CITY OF ALBUQUERQUE

September 14, 2023

RE: 142 40th St. SW
Grading and Drainage Plan
Engineer's Stamp Date: 09/05/23
Hydrology File: K12D037

Based upon the information provided in your submittal received 09/05/2023, the Grading & Drainage Plans **are not** approved for Building Permit and Grading Permit. The following comments need to be addressed for approval of the above referenced project:

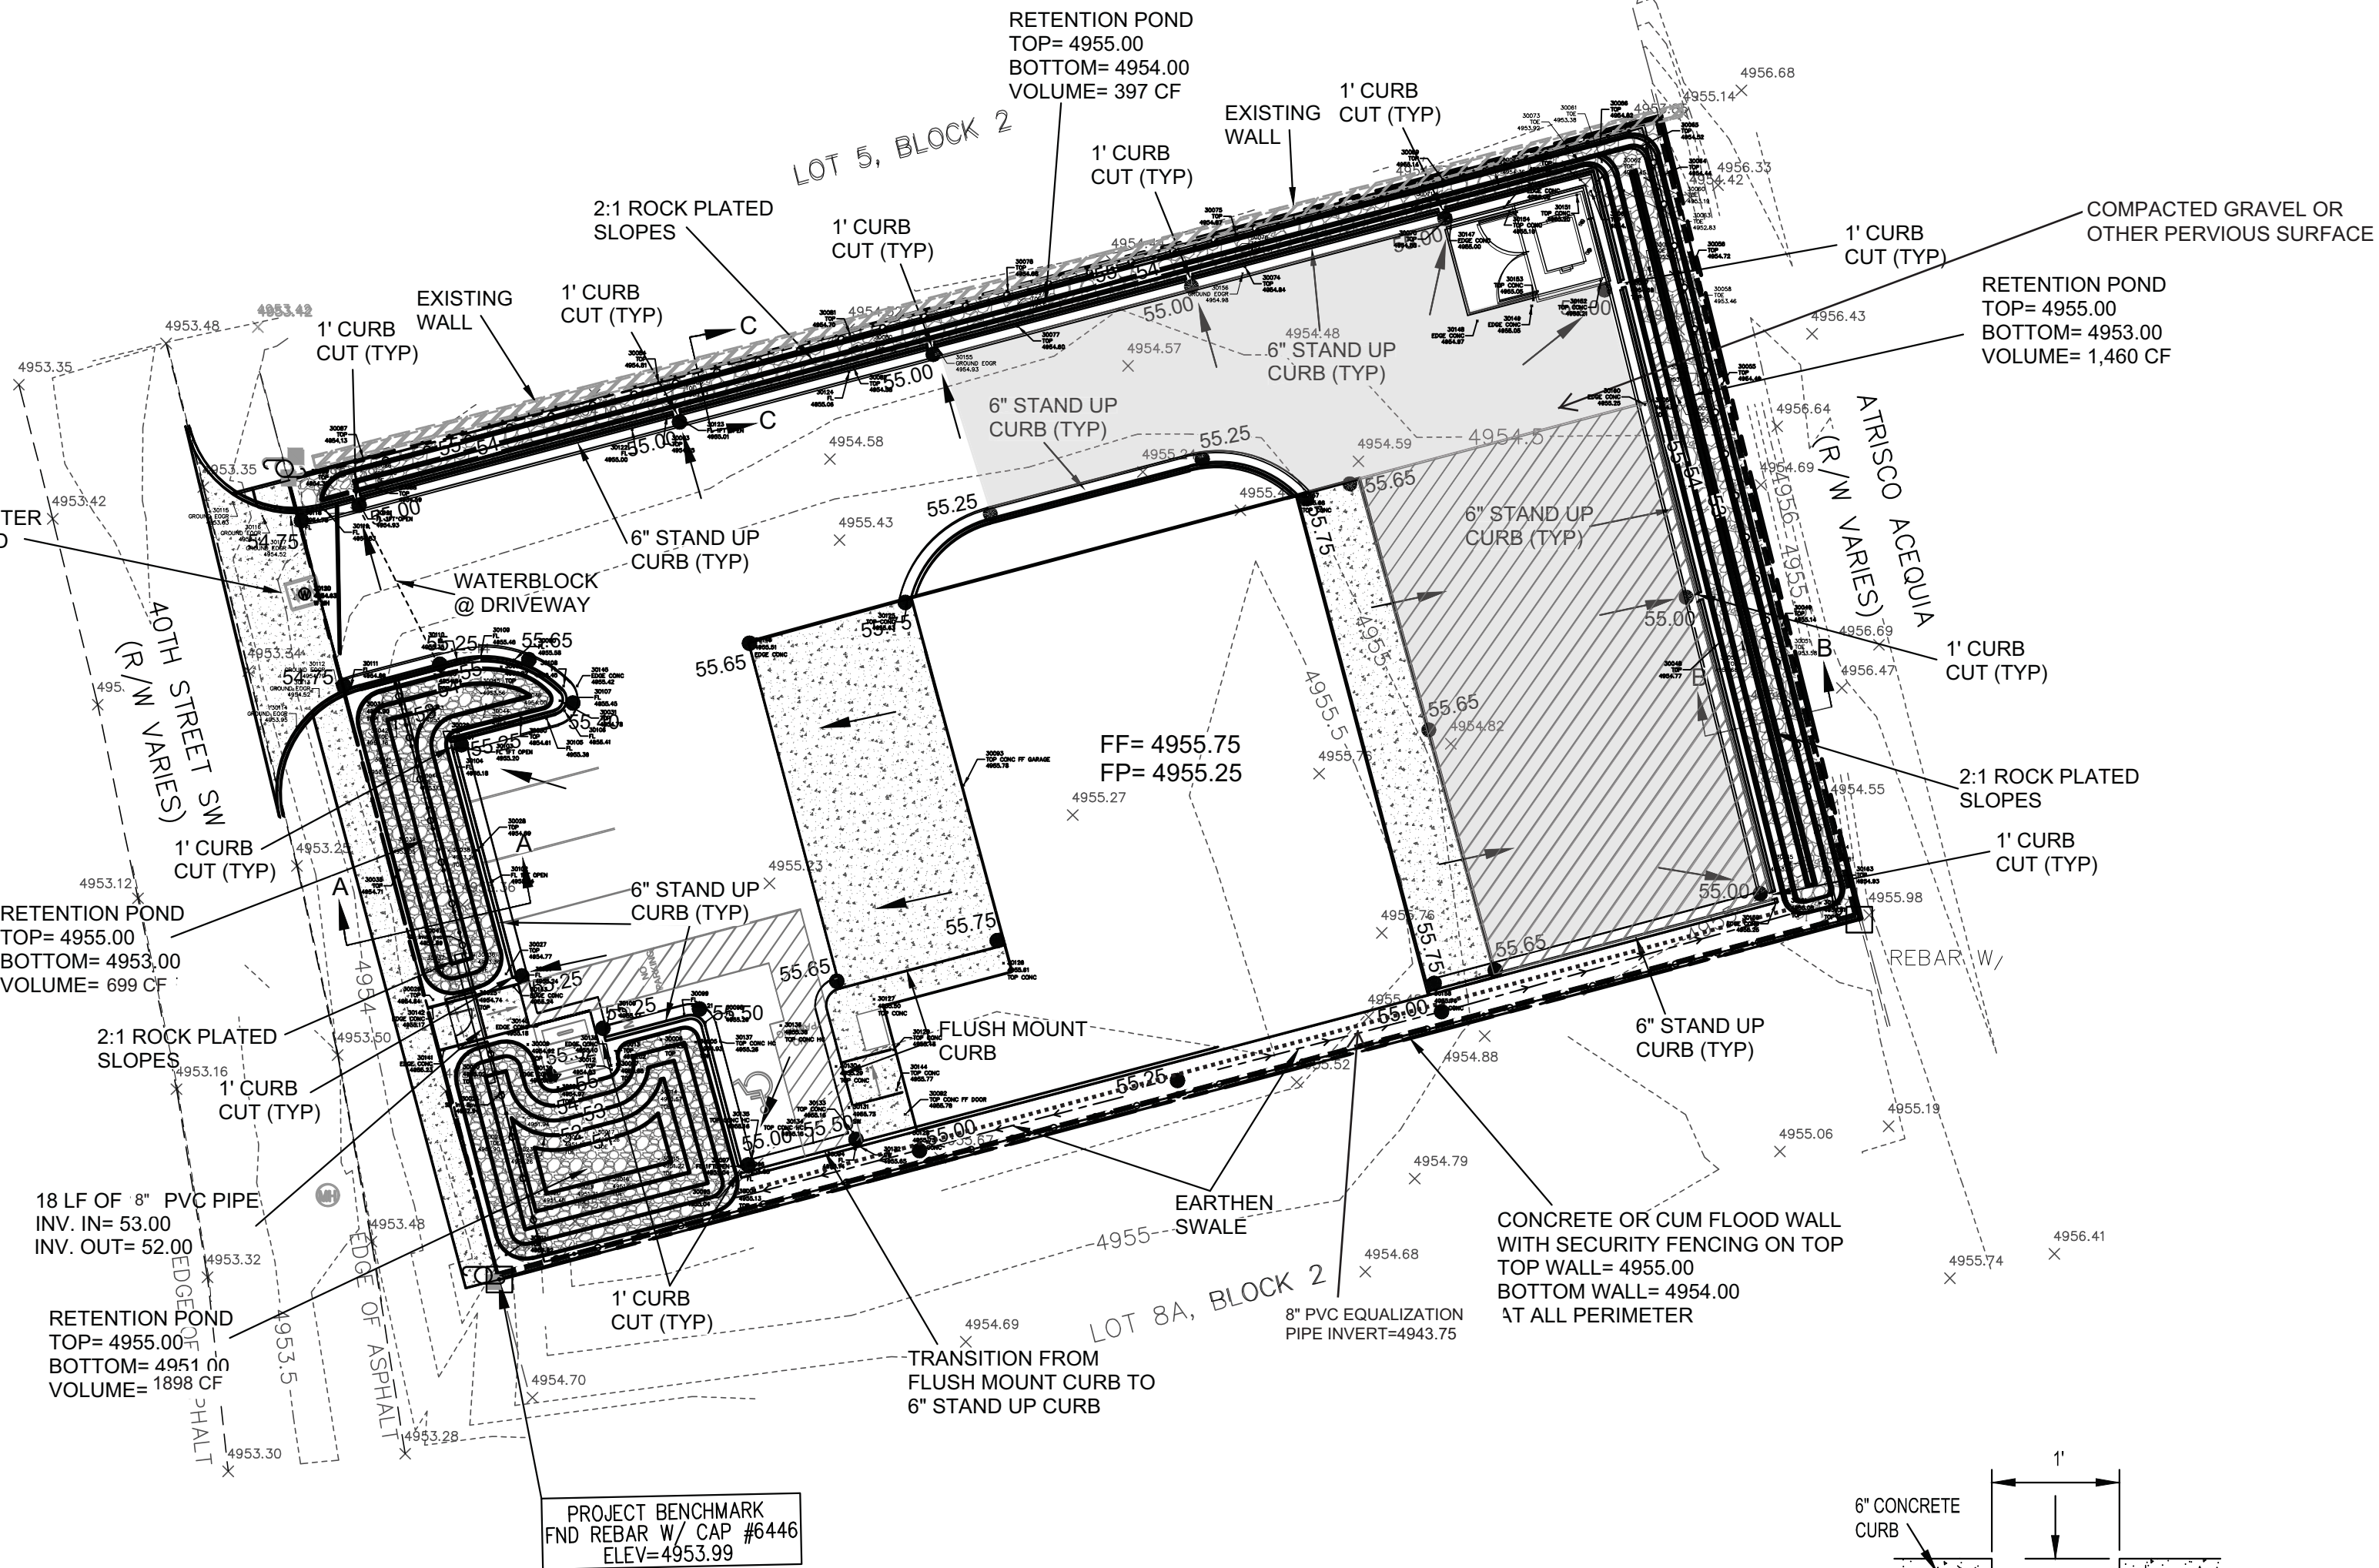
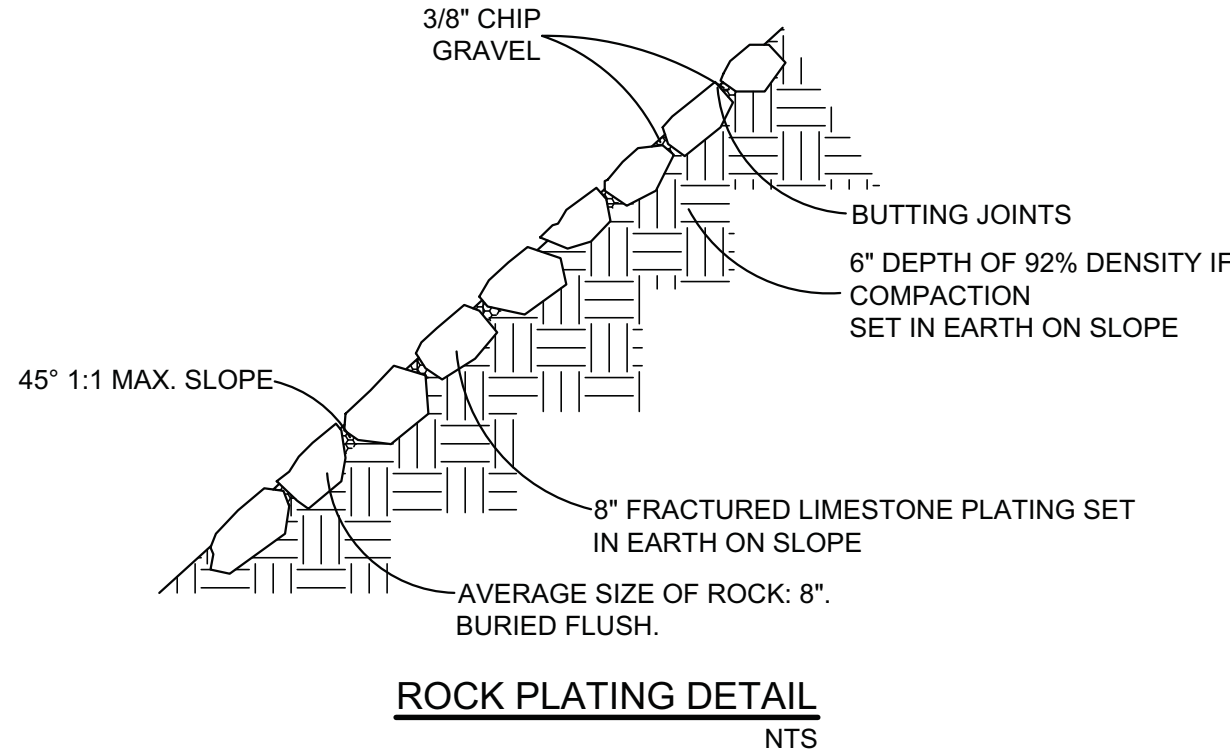
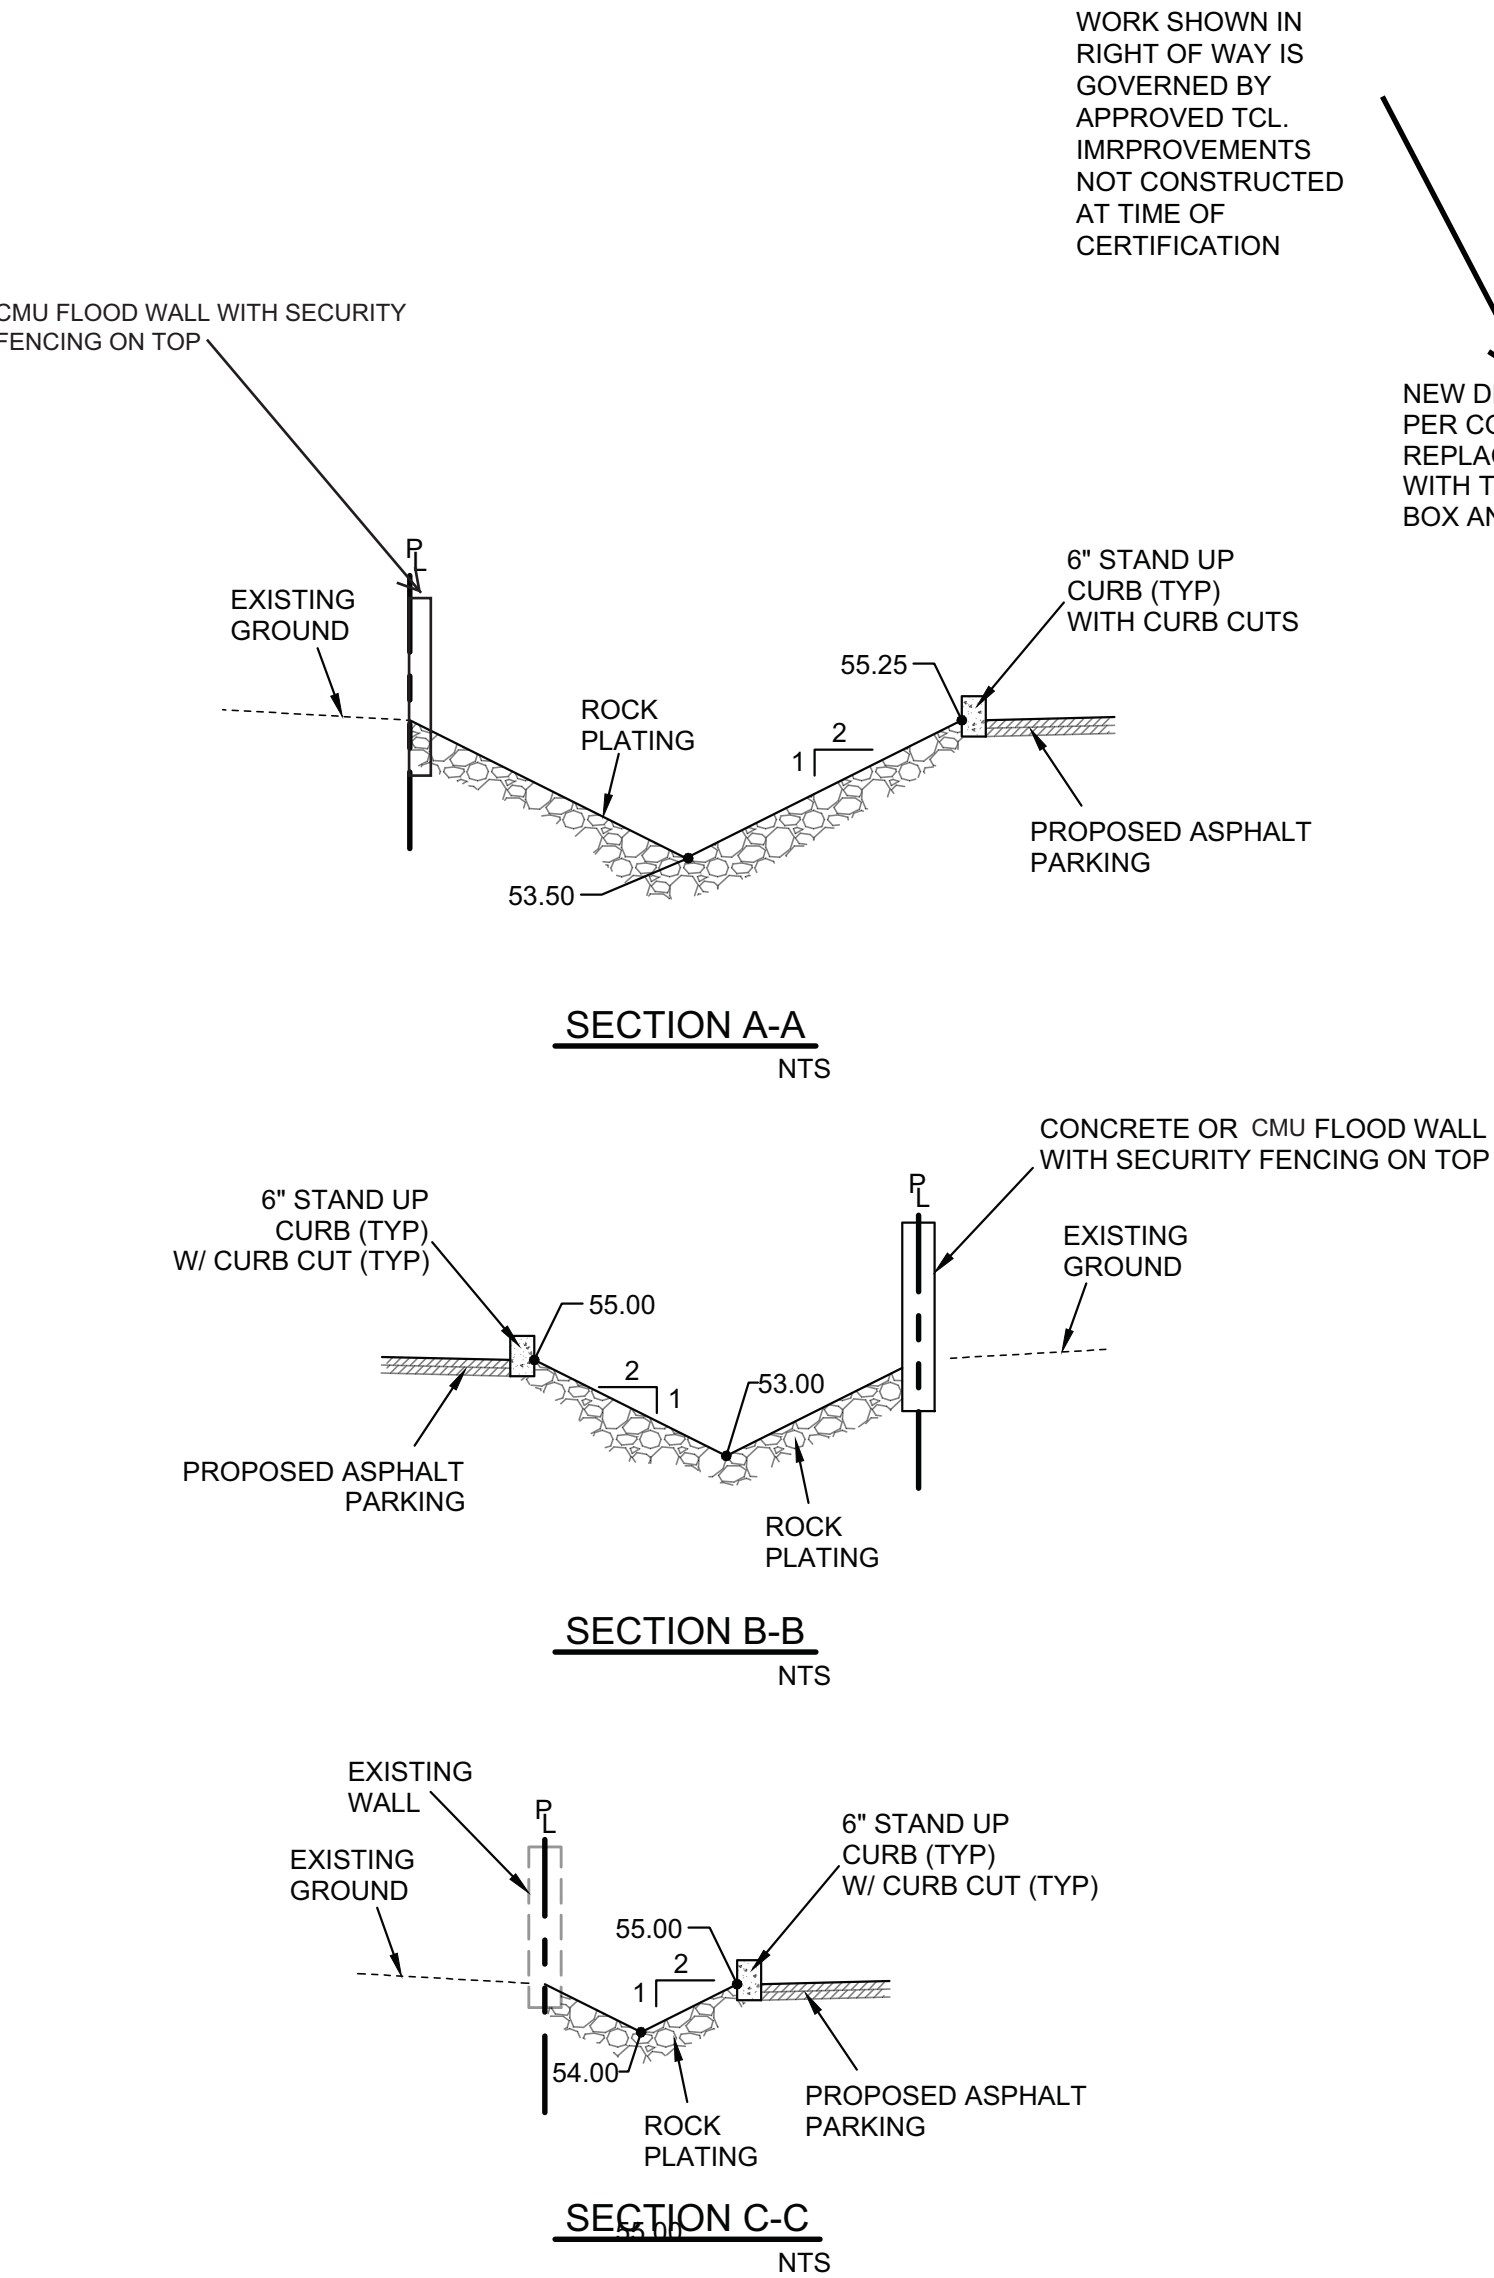
1. Please provide the stormwater quality calculation, multiply the impervious area by 0.26 inches for redevelopment sites.
2. please follow Article 6-5 Valley Drainage Criteria of the DPM. The following conditions must be applied to the site:

- a. The maximum percent impervious of the lot and the contributing area may not be greater than 45%.
 - b. Pad elevation shall be a minimum of one (1) foot above the 100 year 10-day stormwater surface elevation.

- c. The flow between the front yard and back yard cannot be obstructed. The stormwater must be allowed to equalize to the same level between the front yard and back yard.

- d. A permanent perimeter wall or barrier around the development is required to contain the 100 year 24 hour storm developed runoff.
 - e. The high point of the street should be four inches above the 100 year 10-day stormwater surface elevation.

- f. The retention pond is the 100 year 10-day volume and not the 100 year 24 hour volume.
